Upper Dearne Valley Environmental Trust (UDVET)

Response to Application No. 2024/62/91934/E – Proposed Development of 11 Wood Street, Skelmanthorpe, HD8 9BN.

OBJECTION, COMMENTS AND OBSERVATIONS

Date: **January 2024** Drawg No: **LD/242**

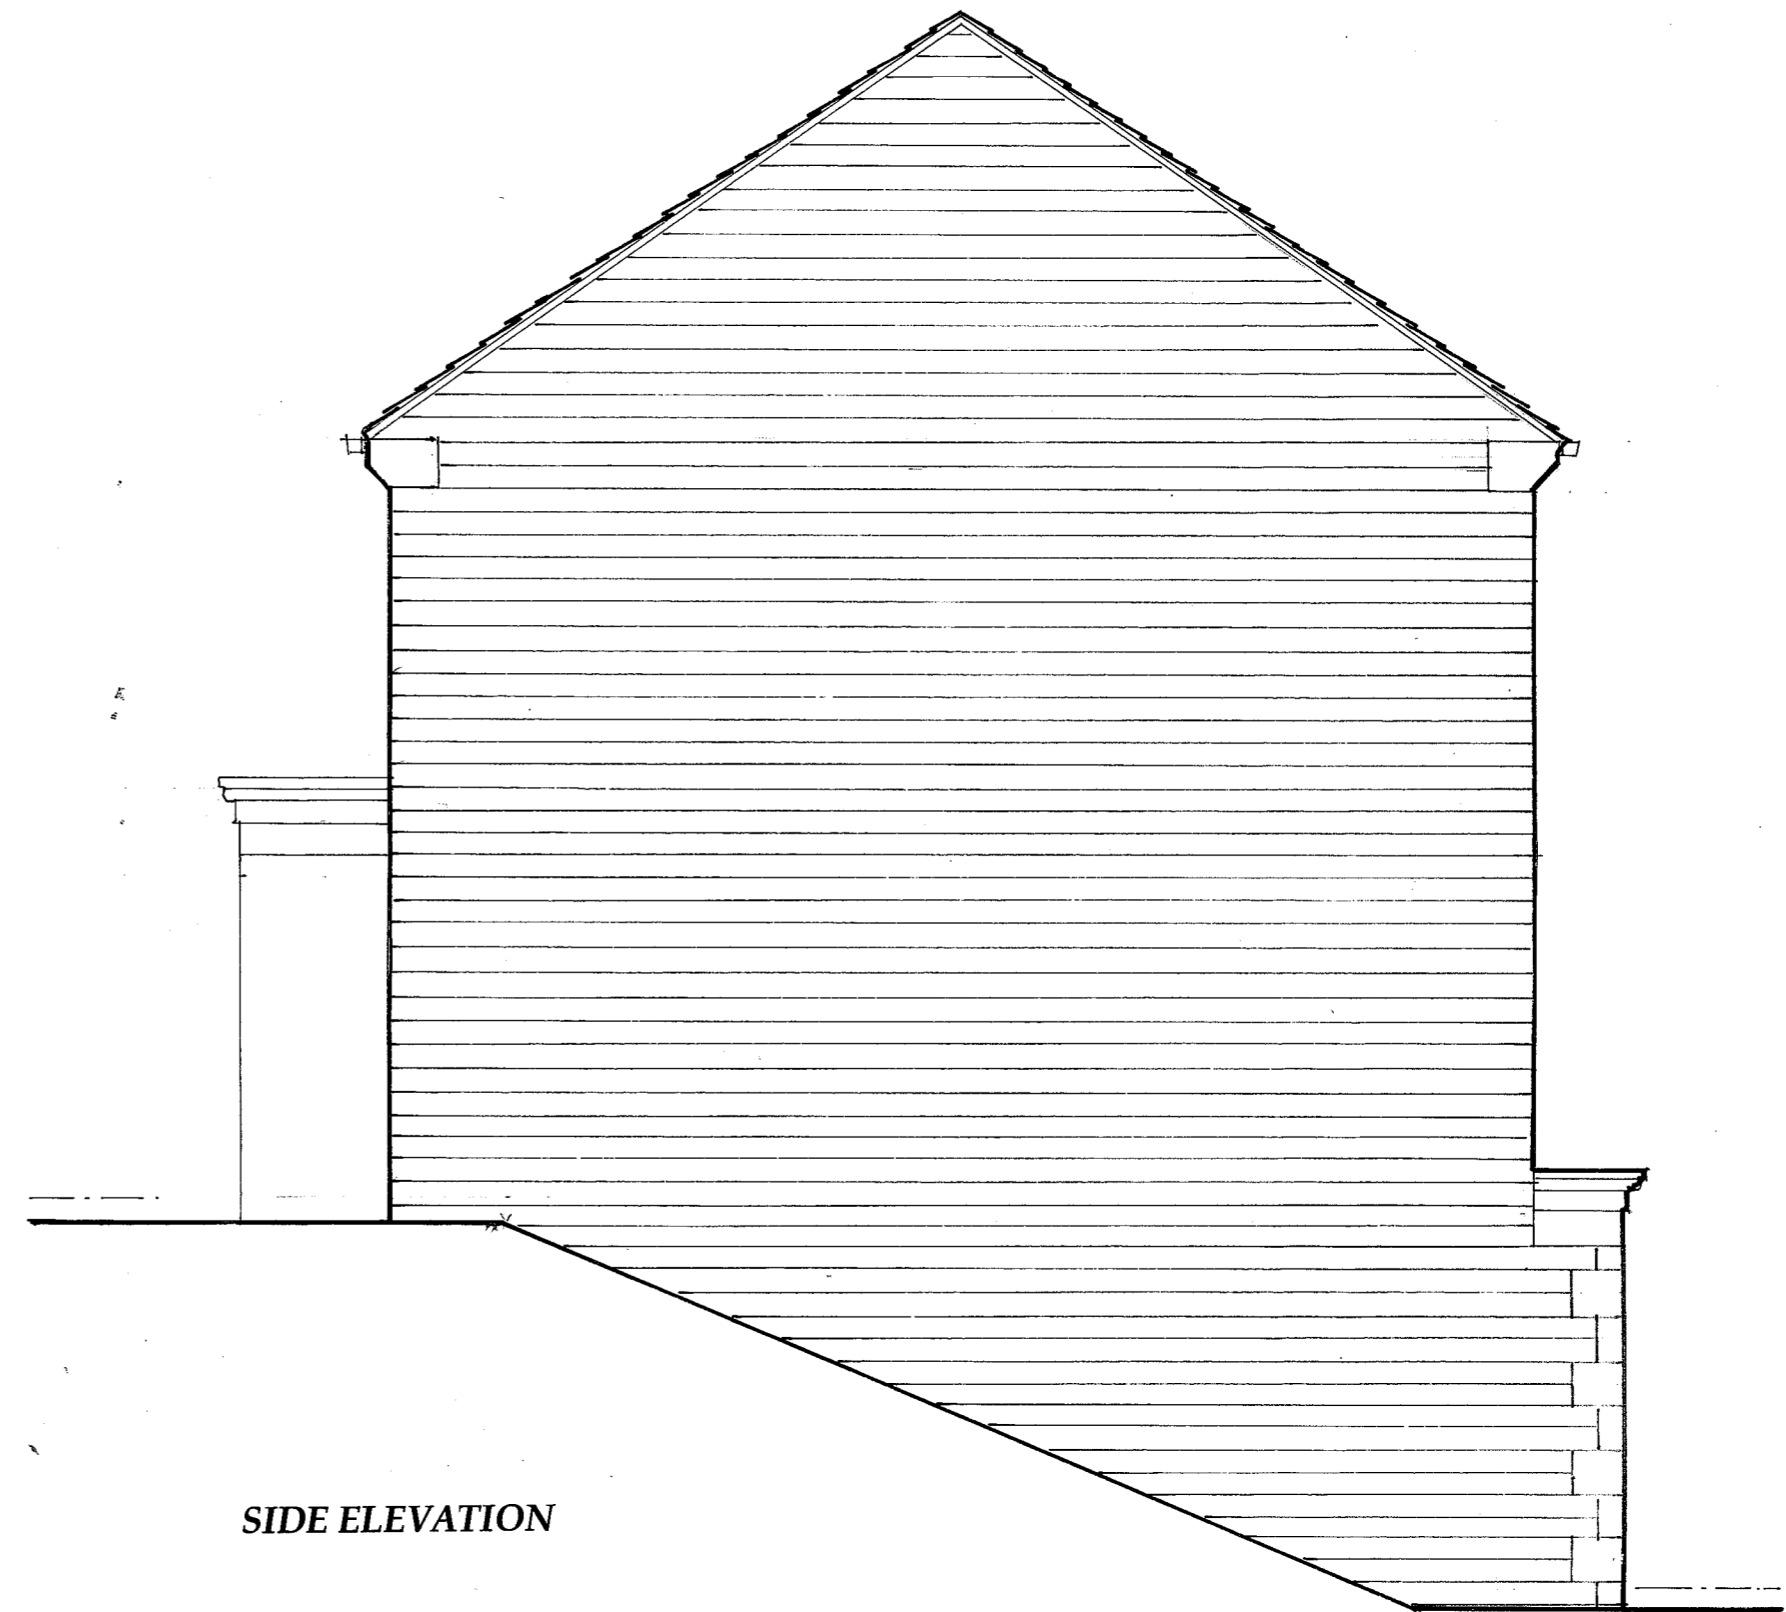
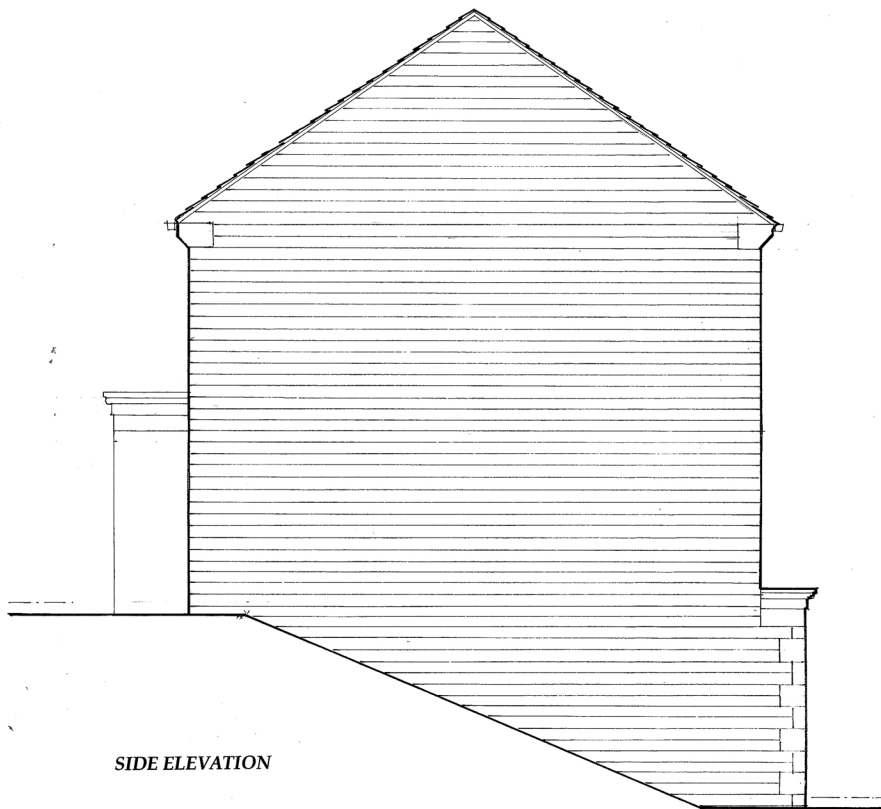
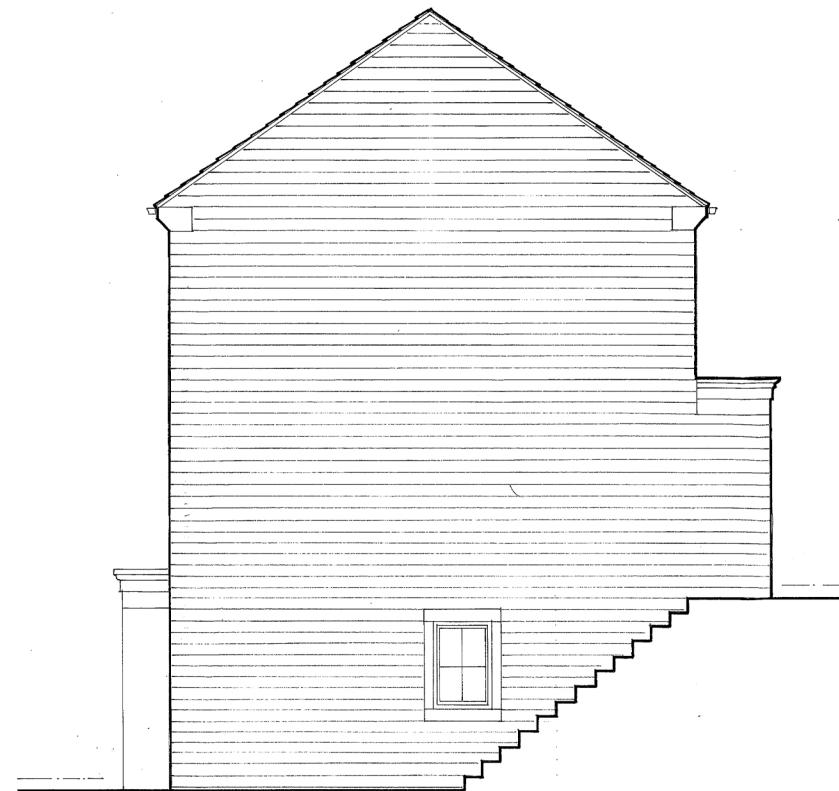
- Parking space dominates the frontages of the proposed housing, against Principle 12 of the Kirklees Housebuilders Design Guide SPD, June 20221.
- The Type A dwellings are ugly 3 storey buildings and will have a negative, overbearing, domineering impact, not only on the site, but the whole immediate area around Wood Street, Station Road and even Elm Street, particularly given they are at the highest (western end of the site). They will also be visible from the west across the greenbelt (as the trees have been destroyed). The living areas and bedrooms are also likely to look directly into the gardens, house and balcony of the bungalow at 11A Wood Street (not shown on the site drawing). The separation distance from 9A Wood Street which also has a balcony at its rear also needs further investigation.

Date: January 2024 Drwg. No: LD/241

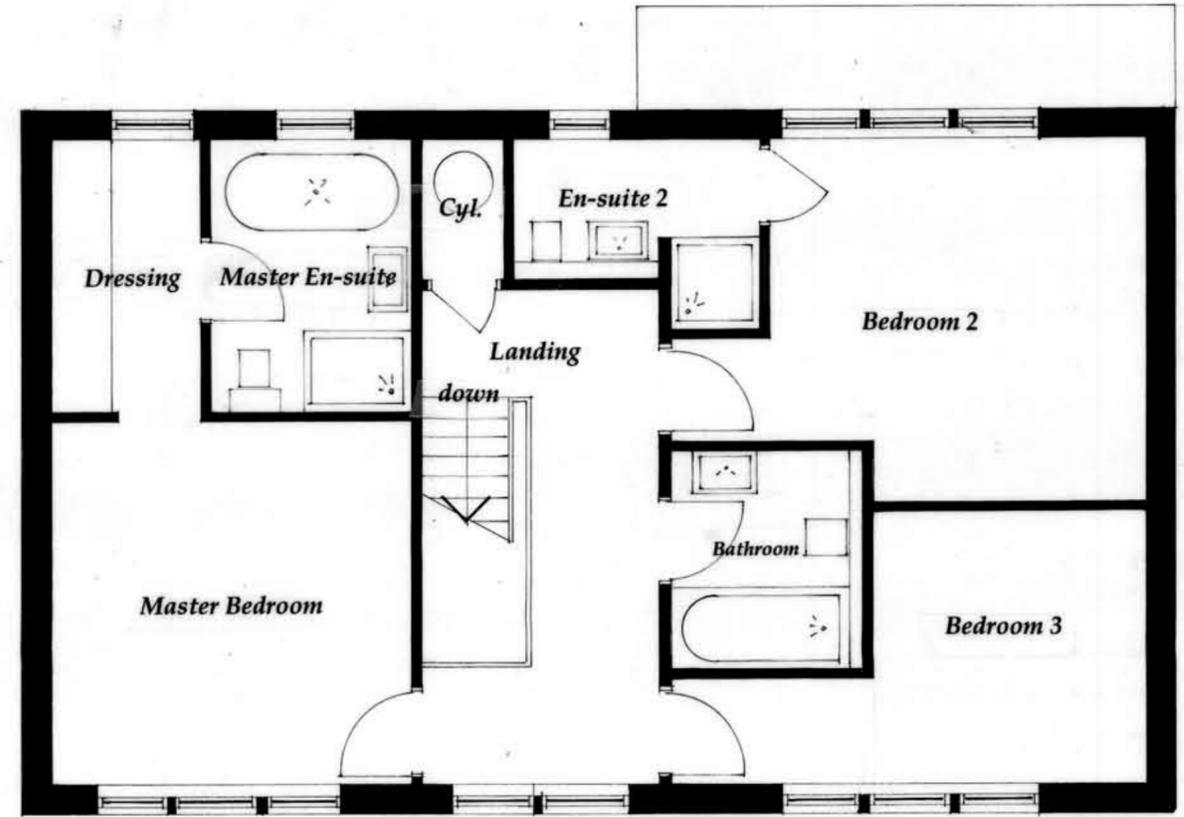
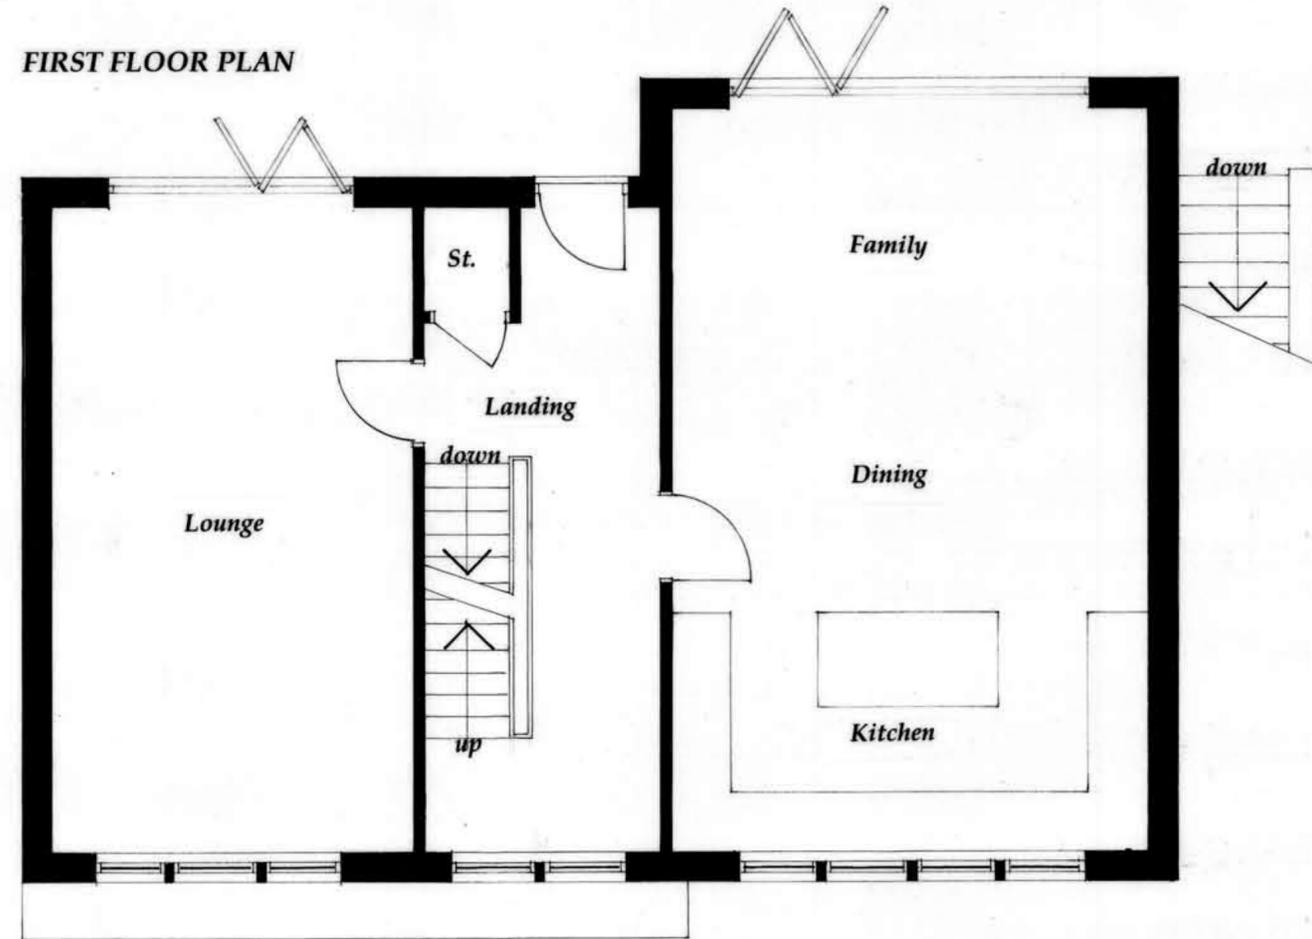
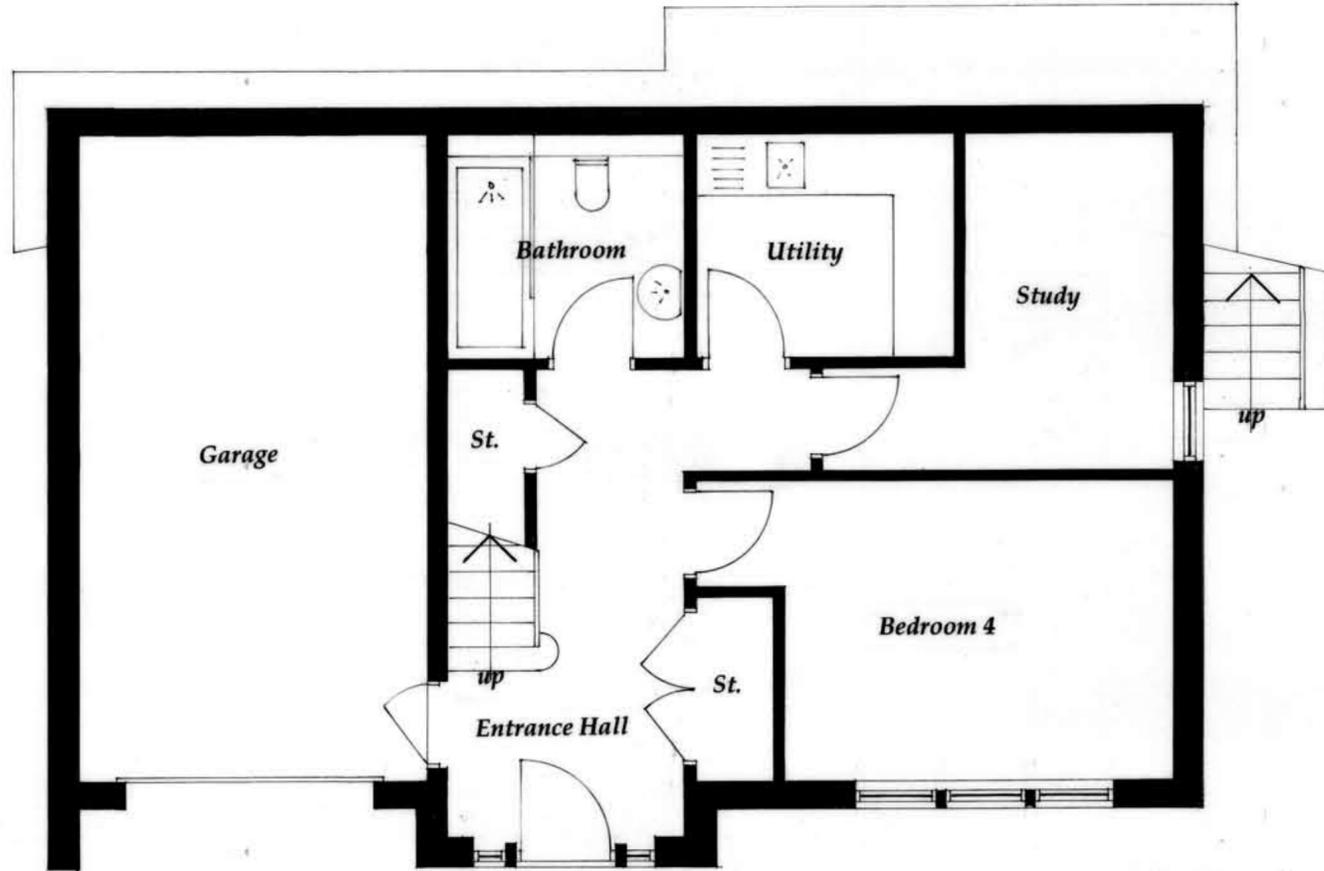
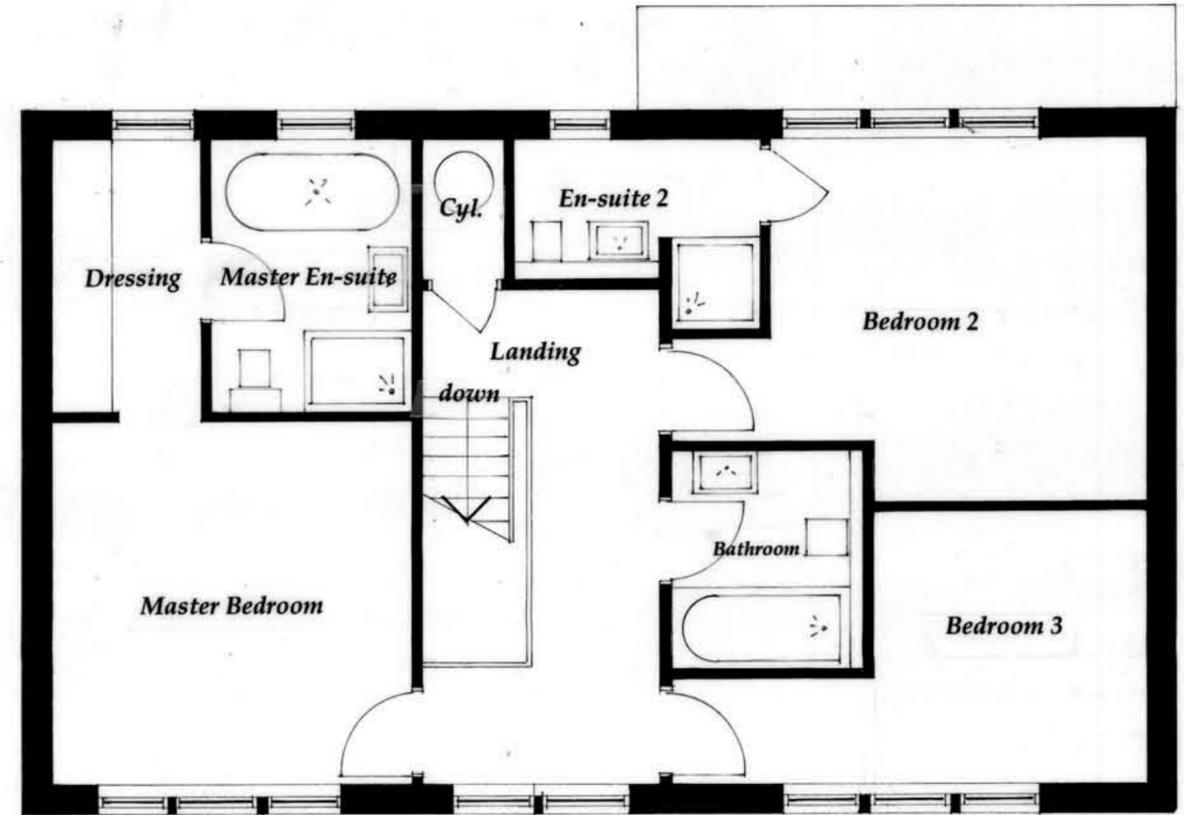
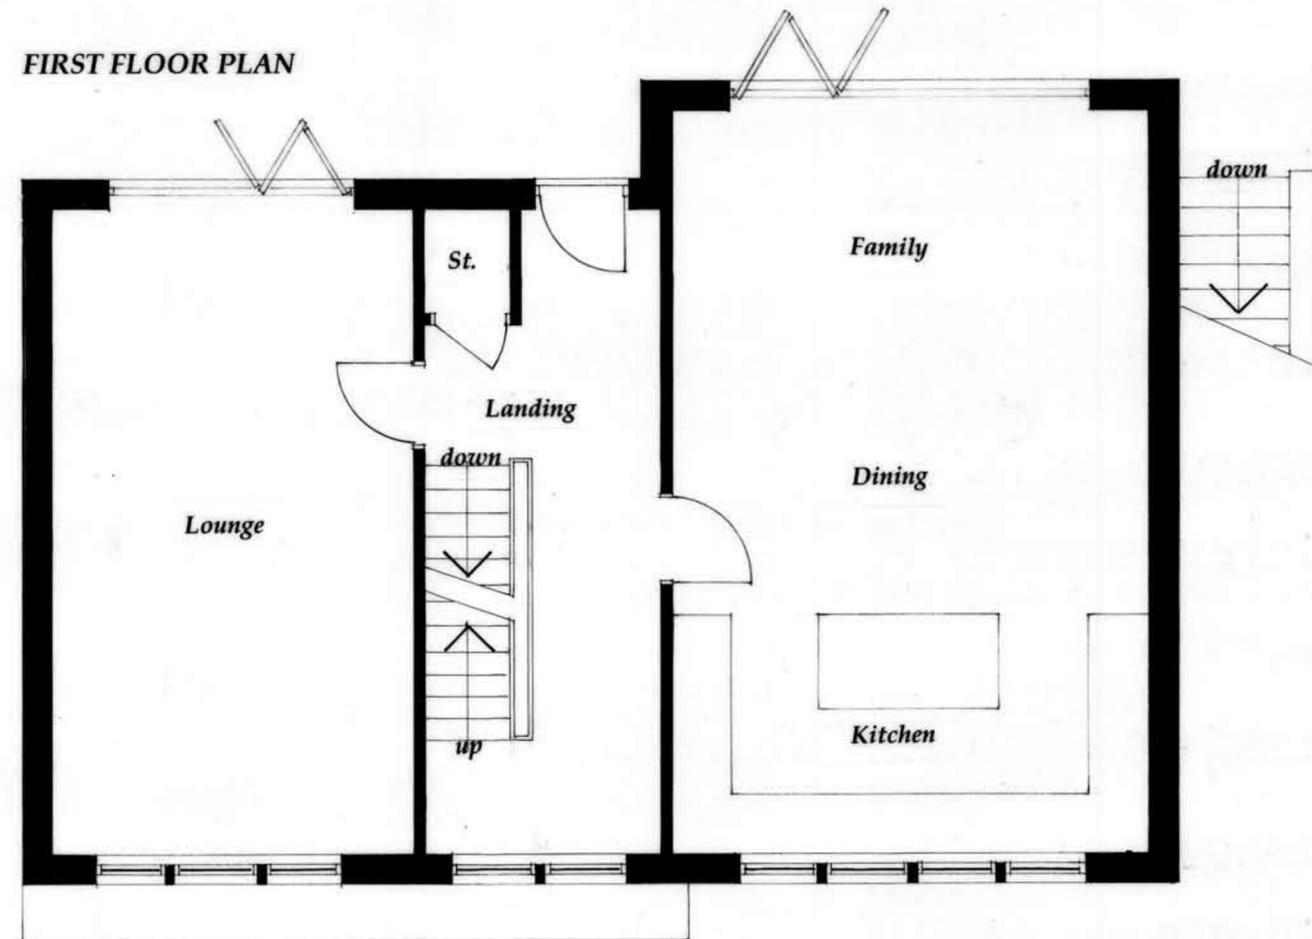
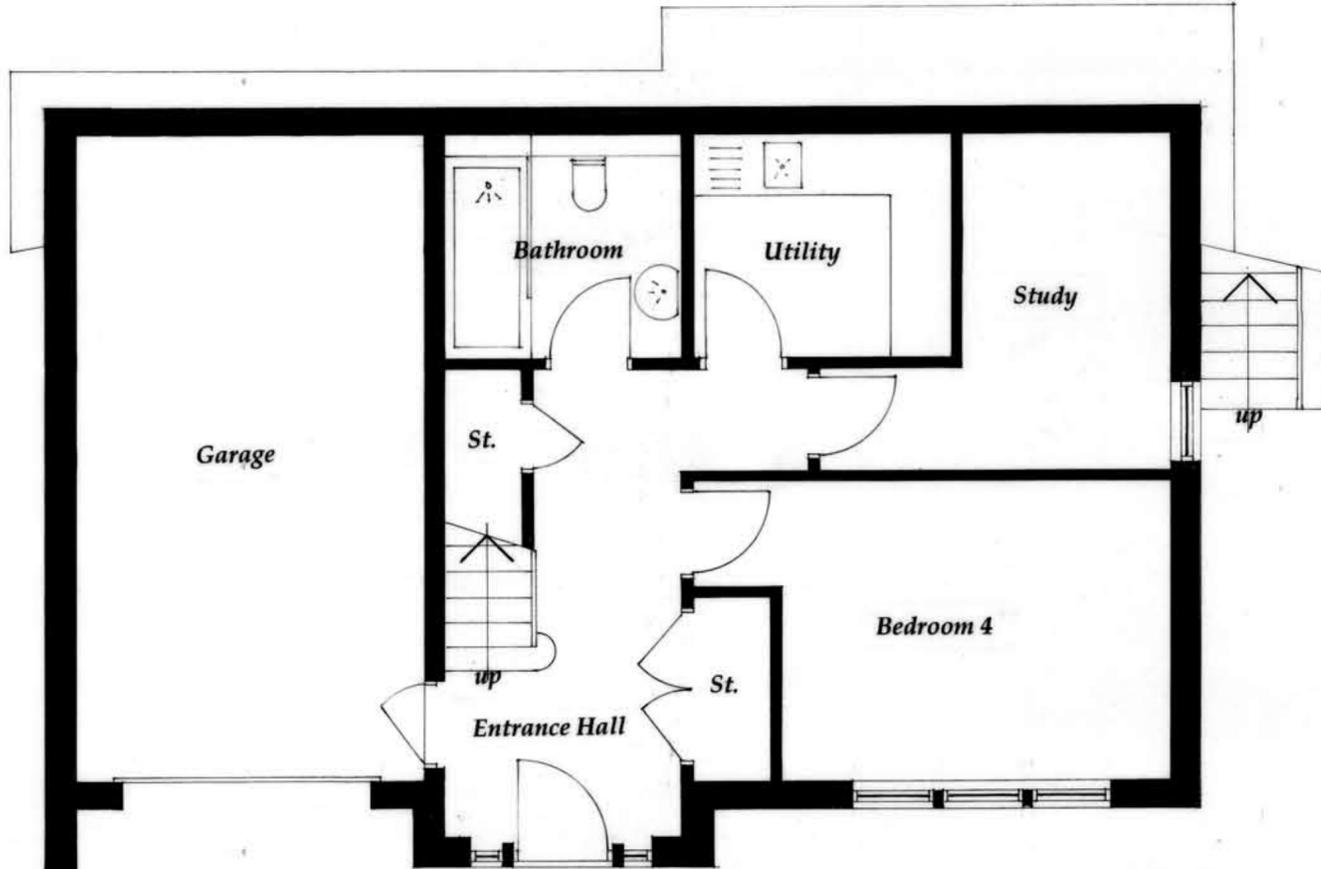
- According to the Kirklees Highway Design Guide 2019, Section 5.4 new, four bedroomed houses should provide three off-street parking spaces. The Type A houses provide only two parking spaces as they have a garage that is too narrow (internally appears to be 8ft 3" only) for modern sized vehicles and therefore, cannot be viewed as a genuine car parking space – they are merely family storage spaces.
